REQUEST

Current Zoning: N1-B (Neighborhood 1)
Proposed Zoning: UR-2(CD) (Urban Residential, Conditional)

Approximately 2.73 acres located east of S Tryon Street, south of Nations Ford Road, and north of Skipwith Place.

The petition proposes to allow 33 single family attached dwelling units on a vacant property on S Tryon Street.

RZ-1

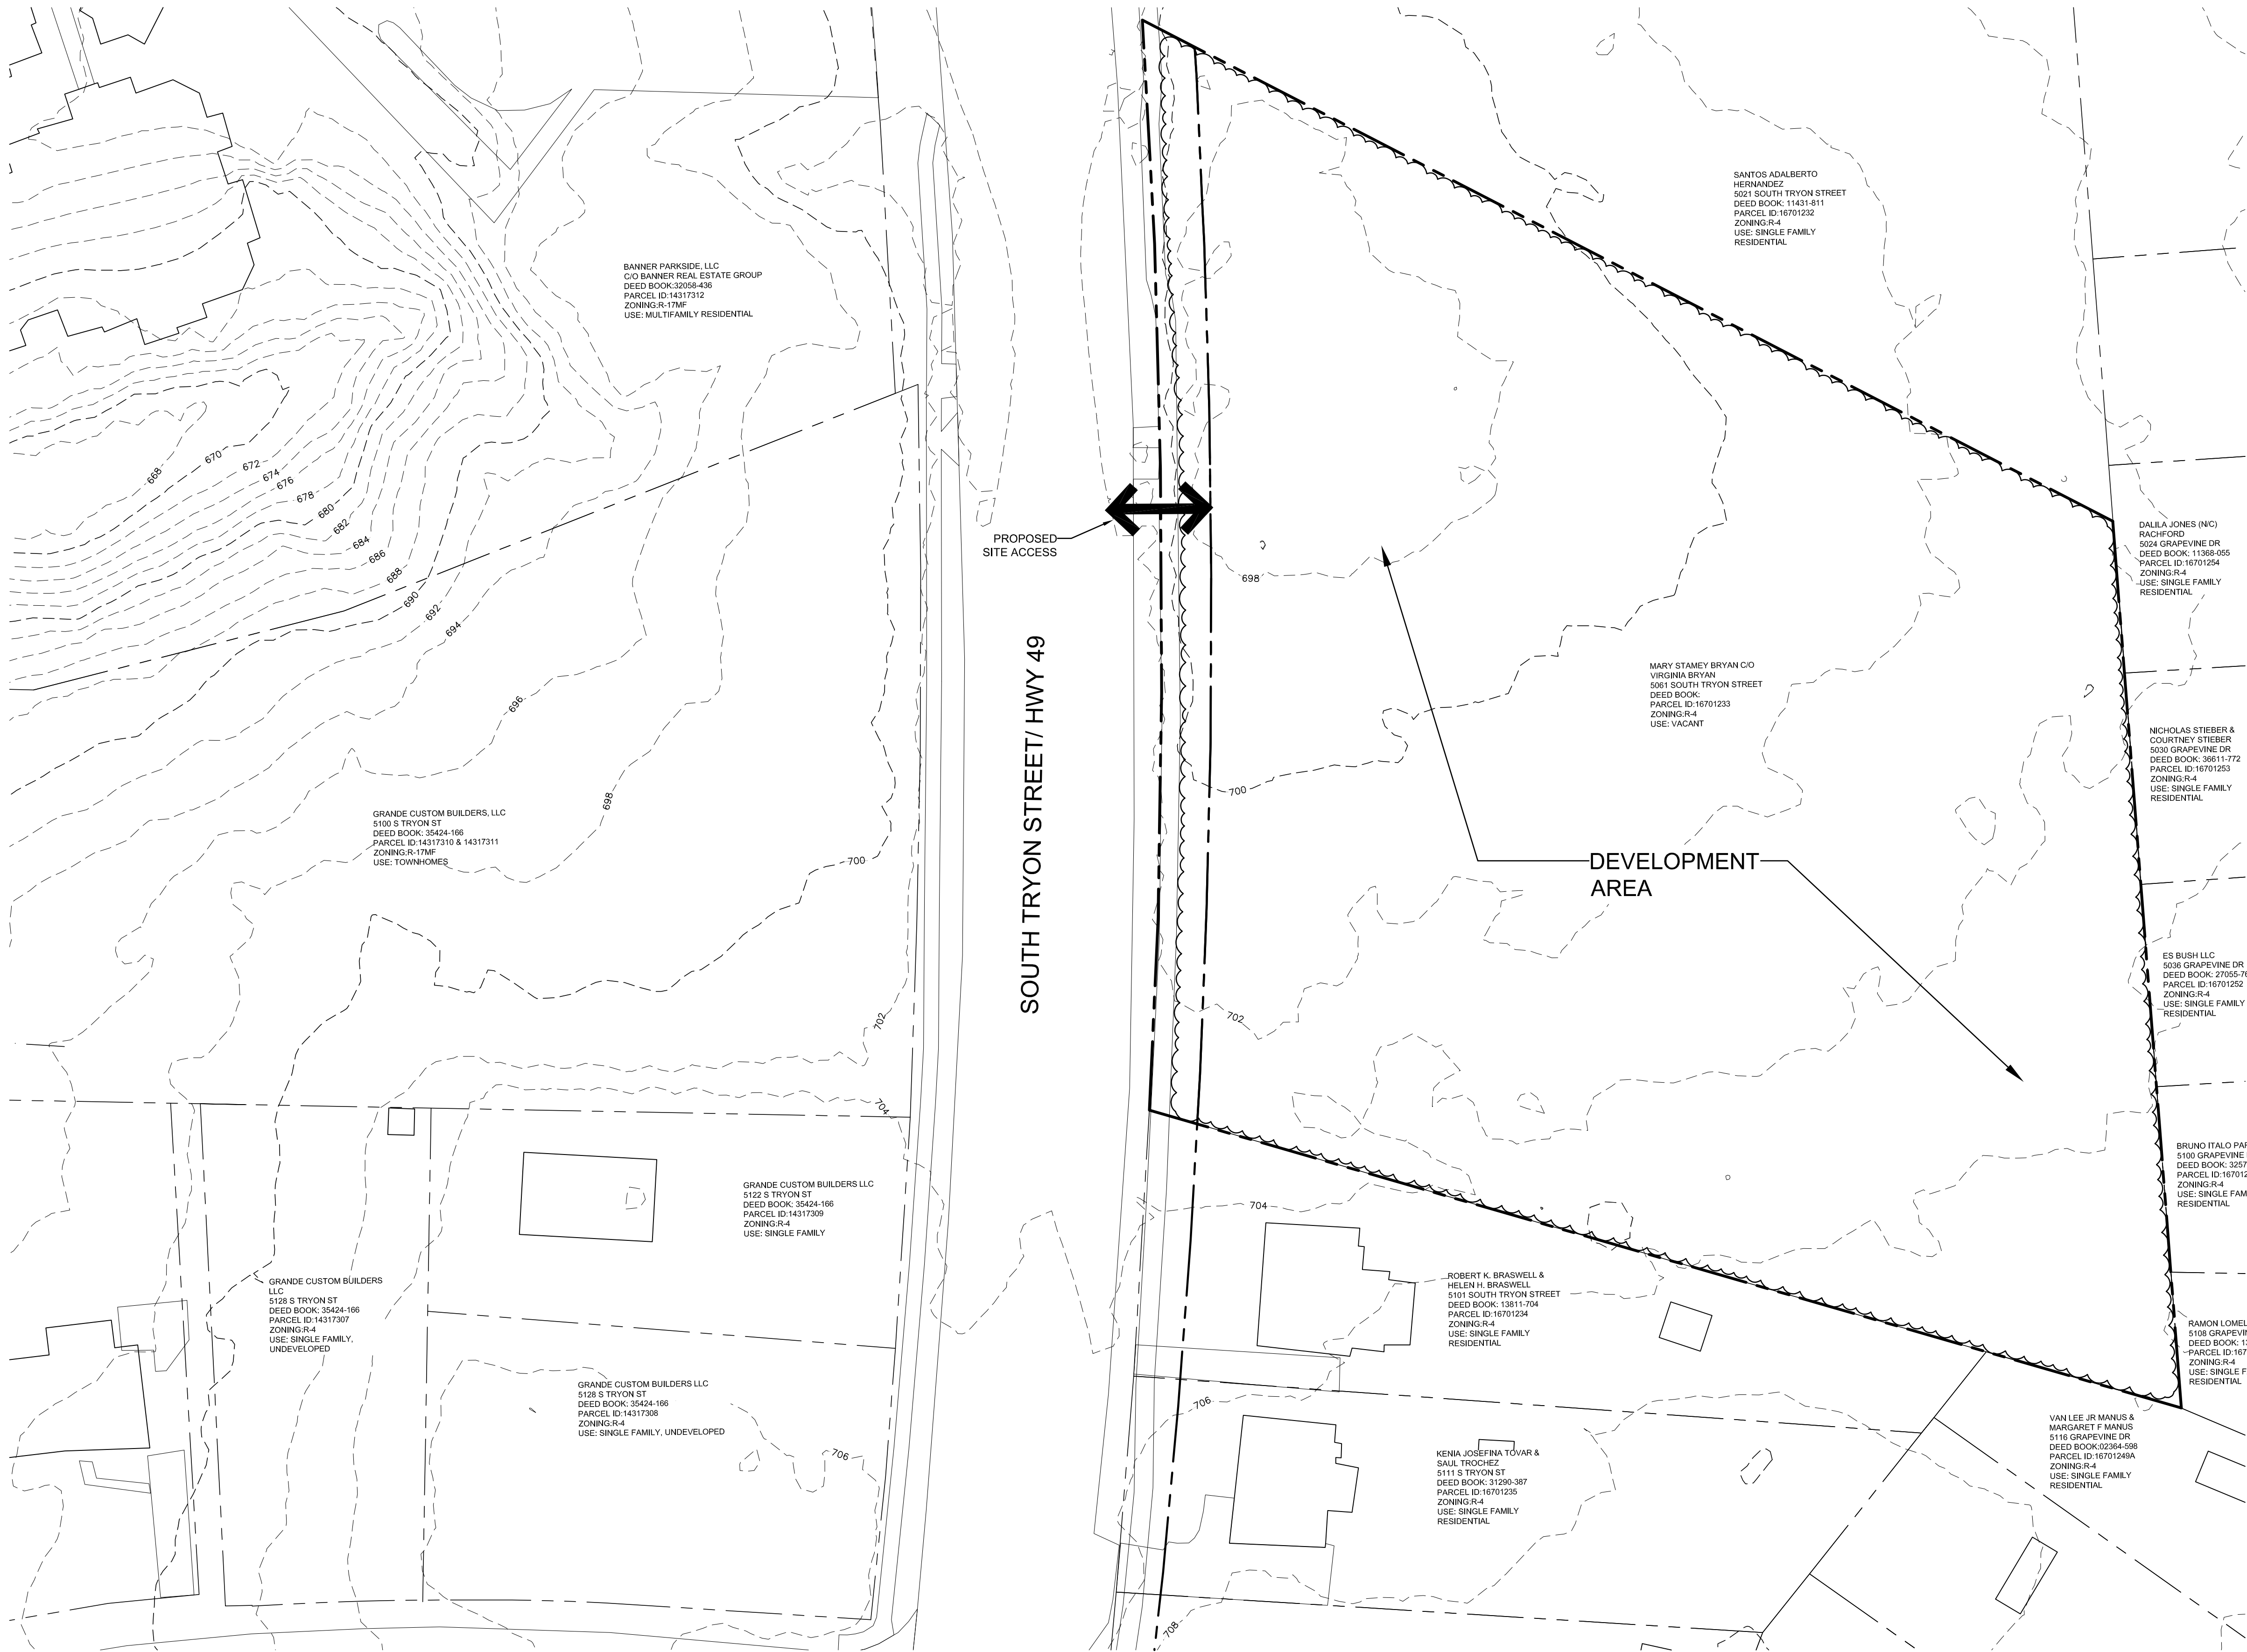
2. Increase minimum setback of S Tryon Street to 20 feet.

1. Remove the following language from note C.8: "required to be constructed by petitioner under this section C of the development standards."
